File Number: 2016/042311  
Our Ref: R/2015/26/B

**RE: State Significant Development 7133 – Response to Submissions,  
Building W1 Student Accommodation, Darling Drive Plot, Sydney International  
Convention, Exhibition and Entertainment Precinct**

### REVIEW OF RESPONSE TO SUBMISSIONS

SITE PLAN

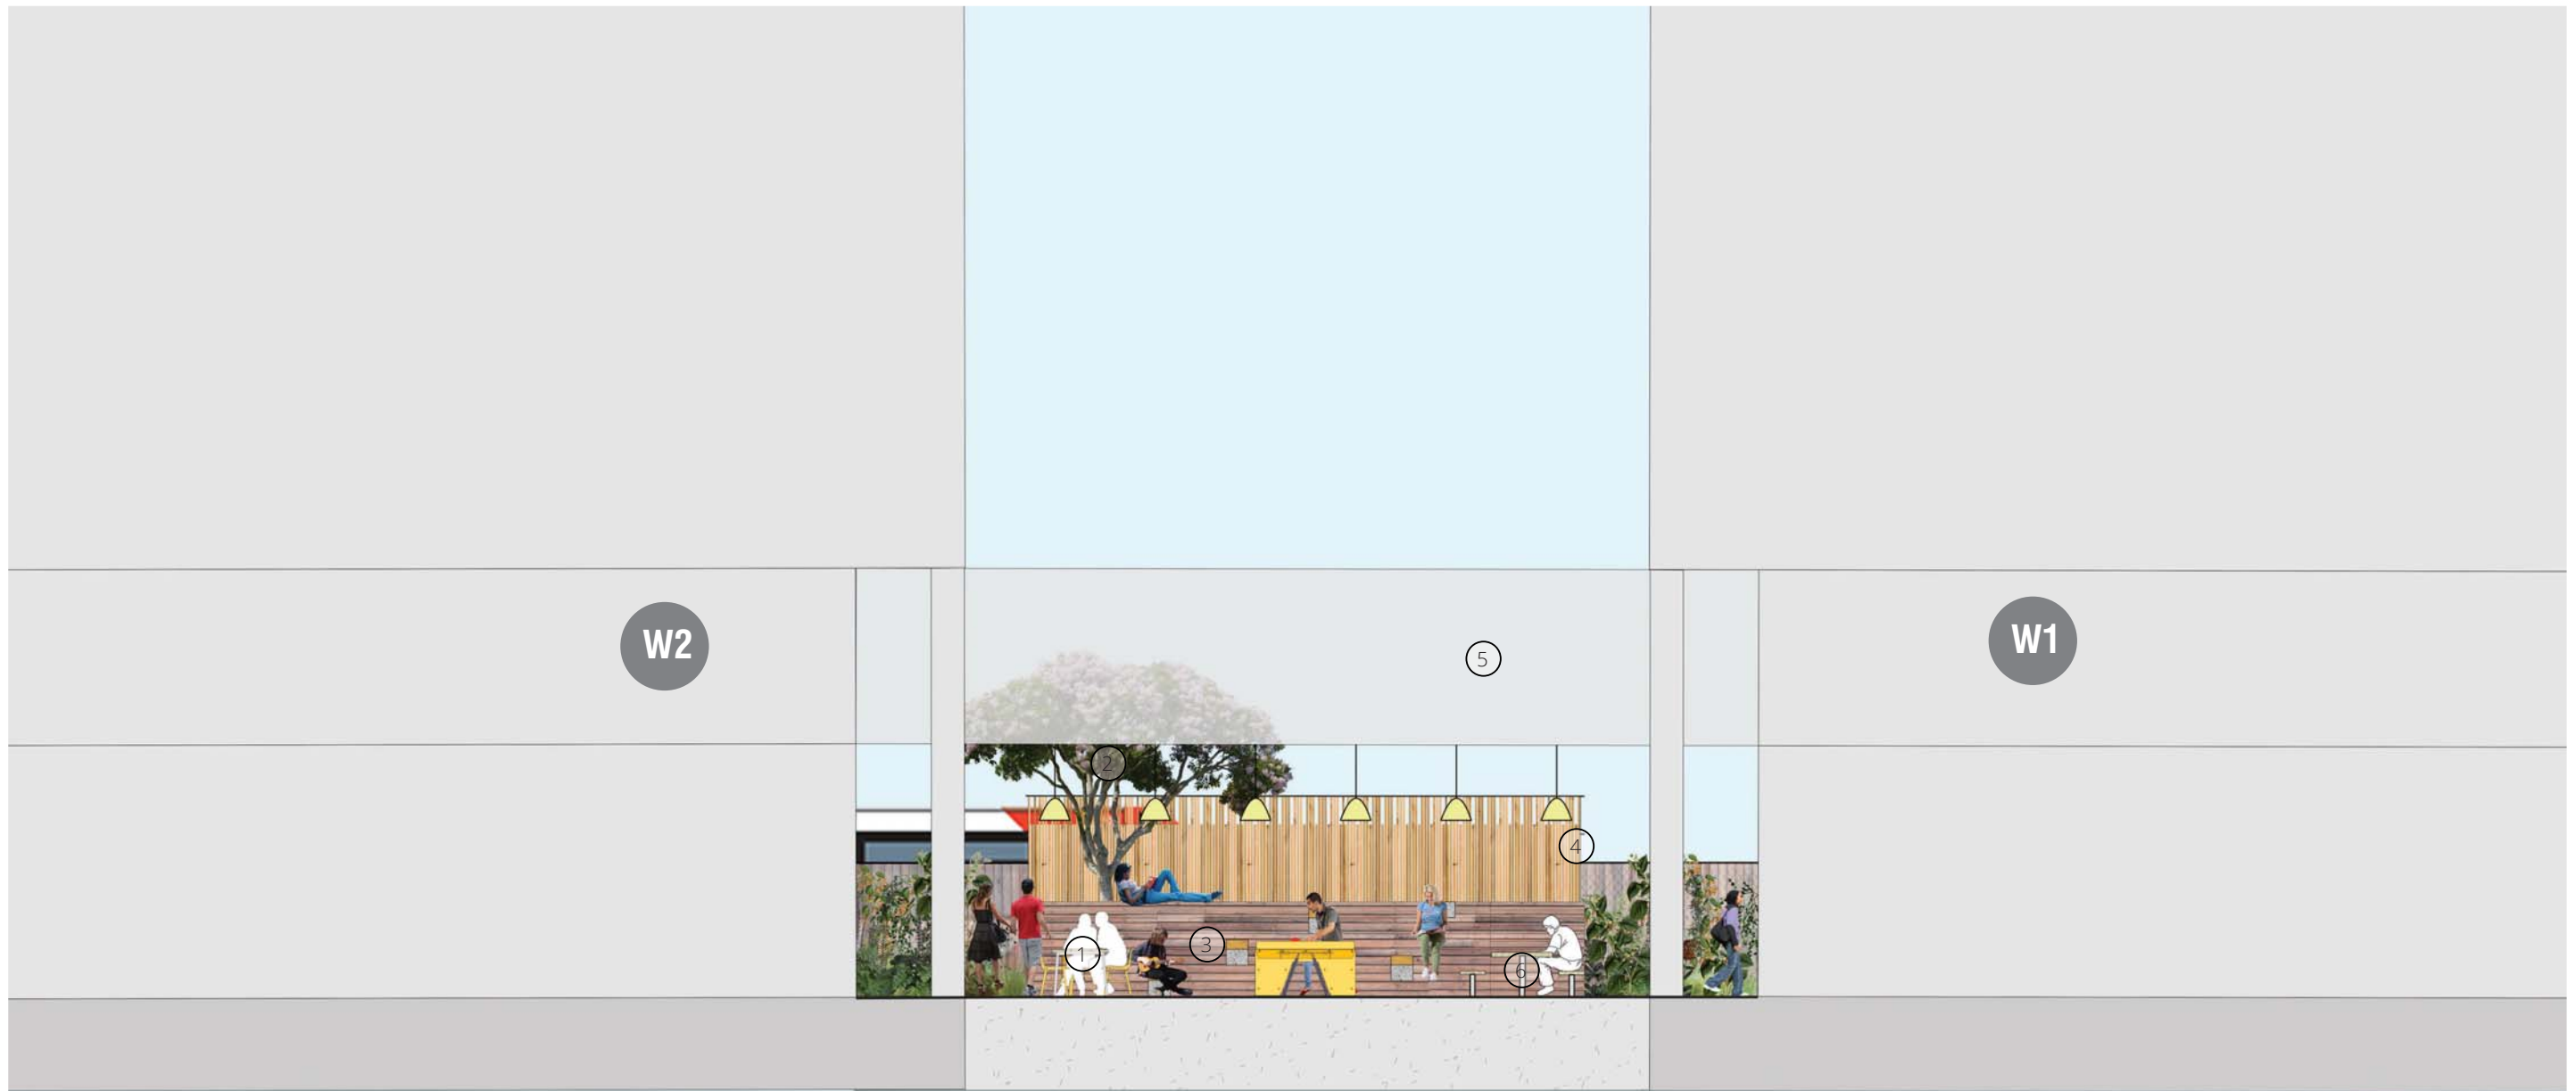
Issue	Applicant's Response	Issue Addressed?	City's Contention
<b>Central Courtyard</b>			
<p><b>Privacy:</b> The central courtyard appears to be designed solely for student use, however is publically accessible. Given the limited activation and overlooking, and the sometimes awkward interface between doors and columns, this space could be better utilised if secured and made private</p>	<p>Privatisation of the central courtyard is not in keeping with the objectives of the wider SICEEP precinct. Permeability of the courtyard is required to allow for waste removal and substation access as prescribed through easements. Design features, such as paving/ground treatments, planter boxes and the bridge link, have been included in the central courtyard to delineate the transition from public to semi-private/semi-public space.</p>	No	<p>Whilst publically accessible open spaces are broadly supported across the SICEEP precinct, the suitability of this approach in this particular location is not supported for the reasons outlined in our original submission.</p> <p>The City's original comments remain unchanged.</p>

<p><b>Activation:</b> The majority of frontage to the central courtyard is services, including garbage and substation. The entrance to building W1, and a possible exit from W2 is the only activation of the space. If the courtyard is secured as recommended above, the applicant should ensure clear and visible access to the space from both buildings.</p>	<p>These essential services are required to be provided in their current location due to access requirements and easements. The proposed use of the central courtyard space ensures that this otherwise neutralised space is optimised for use by the adjacent residents.</p>	No	<p>The City's original comments remain unchanged.</p>
<p><b>Interface between doors &amp; columns:</b> All doors leading to the ground level outdoor spaces appear to be positioned behind columns, further limiting the activation of the spaces, and possibly blocking direct views to</p>	<p>These ingress/egress doors have been amended to allow for suitable clearance.</p>	Yes	<p>No further comment.</p>

Issue	Applicant's Response	Issue Addressed?	City's Contention
the building entries. The applicant should ensure all building entries are clearly visible, and not blocked by columns.			
<b>Boundary to light rail:</b> The boundary between the central courtyard and light rail should be designed as an element that integrates with the built form, unifying the space. The applicant should consider designing an integrated element connecting the two buildings and forming the boundary to the light rail, removing the need for the chainlink fence.	A fence is required to be provided to this boundary to restrict access to the light rail corridor. The treatment of this fence has been determined in discussion with TfNSW.	No	The City understands that a fence is required and must be determined in discussion with TfNSW, however this requirement does not negate the requirement to achieve improved design outcomes wherever possible.  The City's original comments remain unchanged.

LANDSCAPE PLAN - NORTH PARK

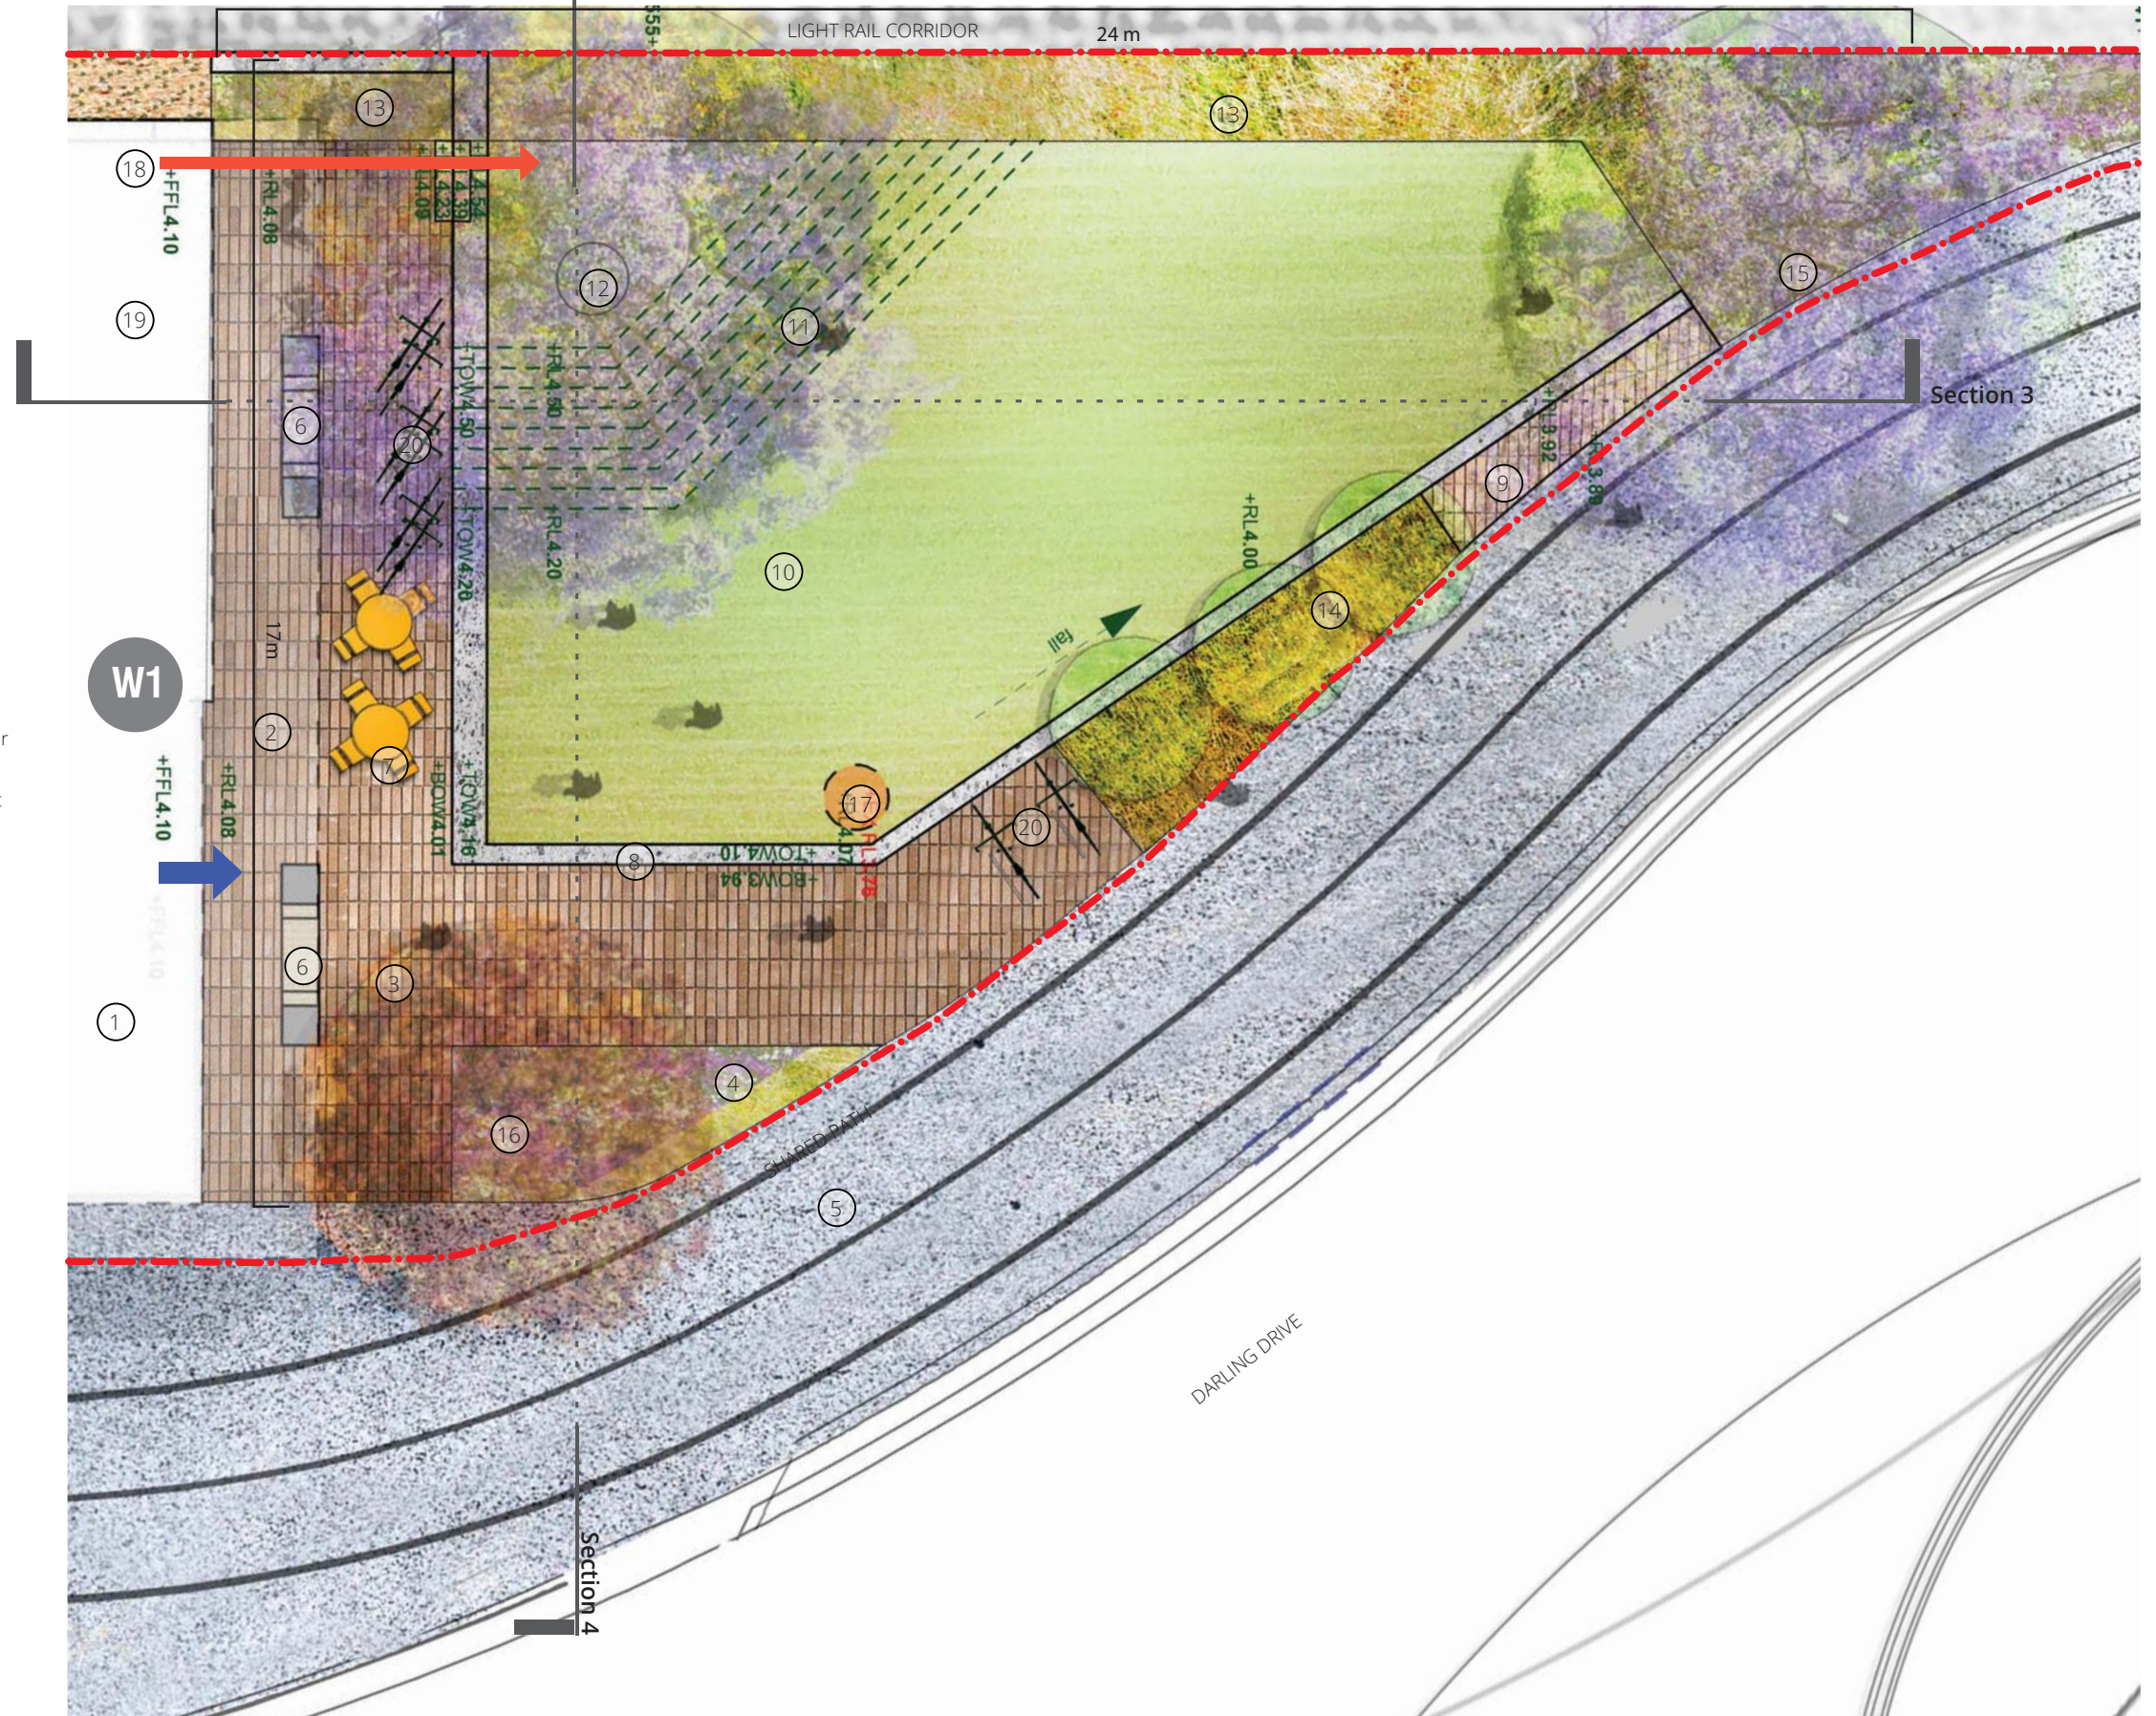
Issue	Applicant's Response	Issue Addressed?	City's Contention
<p><b><i>Bicycle and Motorcycle Parking:</i></b>  The minimum bicycle and motorcycle parking requirements are contained within Clause 30 'standards for boarding houses'. The SEPP requires the provision of one (1) bicycle space and one (1) motorcycle space per five (5) boarding rooms. This would require a total provision of 104 bicycle spaces and 104 motorcycle spaces. This proposal seeks to provide 90 bicycle spaces and nil motorcycle spaces.</p> <p>No objection is raised with regards to the proposed variation to the requirement to provide motorcycle spaces, as it will encourage the residents of this building to use more public transport, walking and cycling.</p> <p>Notwithstanding this, the City objects to the proposal to provide 14 bicycle spaces less than the minimum required by the SEPP. It is noted that, while the Sydney DCP 2012 does not apply, the DCP would require 165 bicycle spaces. While the provision of 165 bicycle spaces would be the preferred outcome, it is our view that 104 spaces should be provided as a minimum in line with the requirements of the SEPP.</p>	<p>It is not considered practical to provide additional bicycle spaces. If additional bicycle spaces were to be provided, the bicycle storage area would encroach on the common area of the ground floor, impacting on the amenity of this space and the ability for the space to be used by residents. Additional bicycle spaces can be provided in the Northern Park, however these would not meet the requirements for visitor parking as they could not be enclosed. These spaces would also encroach on the open space provided within the Northern Park.</p>	<p>No</p>	<p>The City's original comments remain unchanged.</p>

Issue	Applicant's Response	Issue Addressed?	City's Contention
<p>Bicycle parking for visitors is to provide in an accessible on-grade location near a major public entrance to the development and is to be sign posted. The layout, design and security of bicycle facilities must comply with the minimum requirements of <i>Australian Standard AS 2890.3:2015 Parking Facilities Part 3: Bicycle Parking Facilities</i>. The bicycle parking place should be located close to entry/exit points and subject to security camera surveillance where such security system exists. A safe path of travel from bike parking areas to entry/exit points is to be marked.</p>			
<b>Building Design</b>			
<p><b>Western façade:</b> It is unclear from the proposal how the facade which fronts the heavy rail corridor is proposed to be accessed for cleaning and maintenance. Further clarity is required to confirm that the use of the building maintenance unit on the south elevation will not impact on the operation of the heavy rail corridor.</p>	<p>Refer to DA2103, as amended. The façade of Building W1 has been designed with a relationship to Building W2, with variation provided to the north eastern addressing the open corner site. Similarly to Building W2, all facades are accessed by a Building Maintenance Unit (BMU) located on the roof (BMU added to the Roof Plan for clarity).</p>	Yes	No further comment.
